Re: SSD 9483 Chatswood Public School and Chatswood High Schools

The following submission is made in response to the NSW government proposals for Chatswood Public School (CPS) and Chatswood High School (CHS).

Building T Elevations

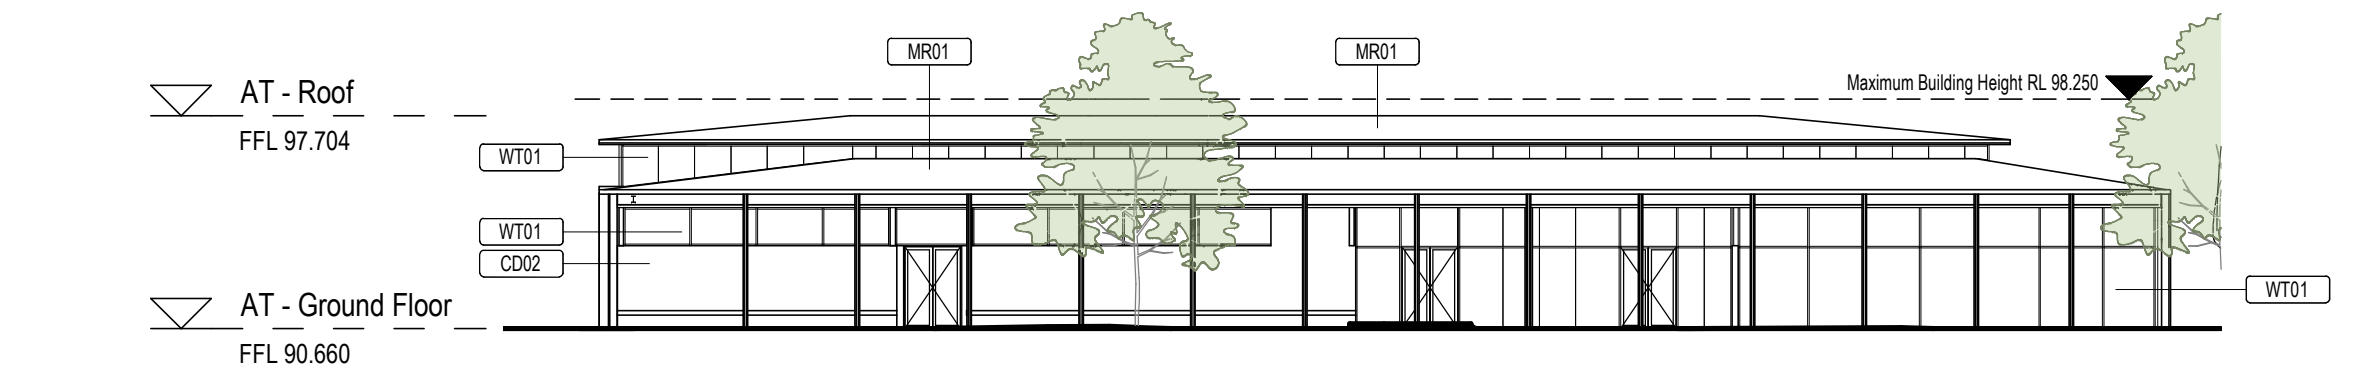
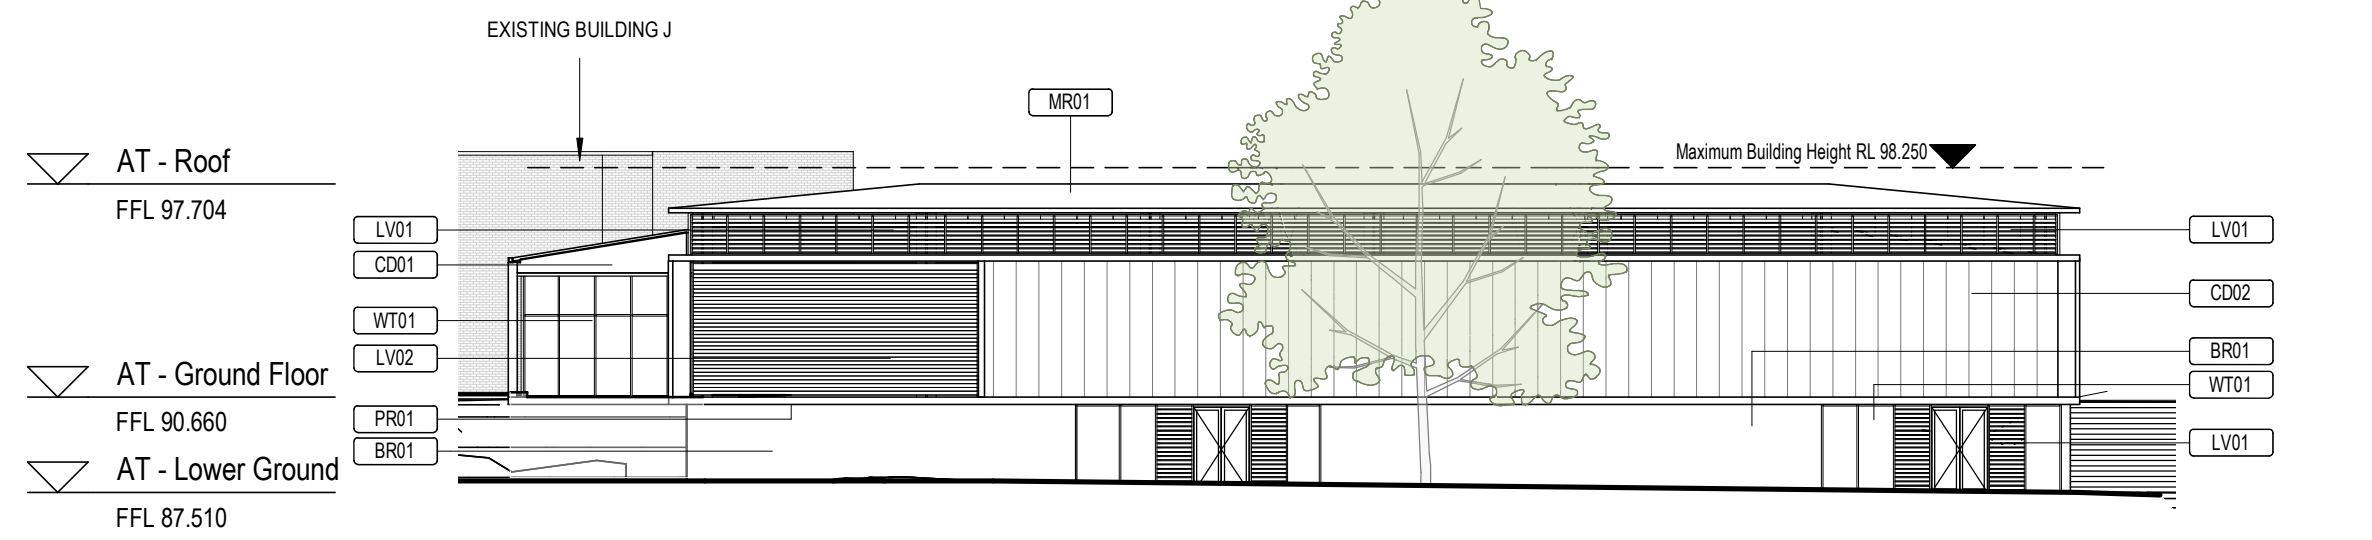
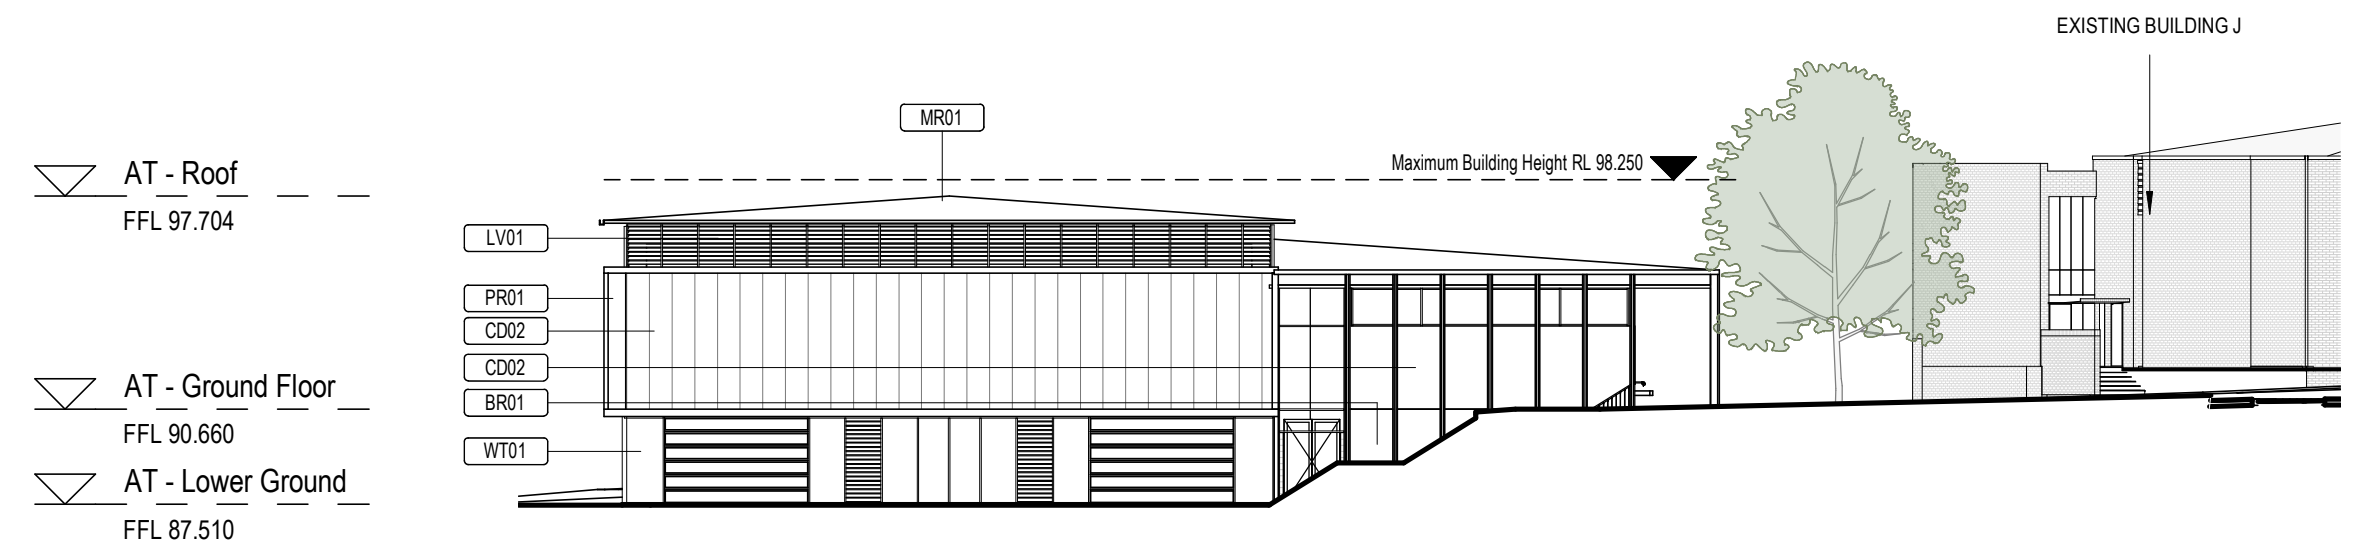
Beyond simplistic outline drawings there is need to properly inform the community of the visual perspective of building T, beyond a statement that it will be brick, concrete and glass. Will building T be constructed of sound absorbing concrete panels specifically designed for these situations? The western wall of building T is approx. 50 metres long, two stories high and with the roofline above that, and broadside on. It sits high on elevated land and presents massive bulk to those properties located on Dardanelles Rd. Trees may break some of the visual impact, however from the drawings it appears that the wall will be a flat, uninterrupted panel devoid of any architectural features or visual relief.

Recommendation: That the external design principals, architectural features, form, any articulation, its context to the site and residential area, should be clearly explained and illustrated to clearly inform the community of what the proposed buildings will look like.
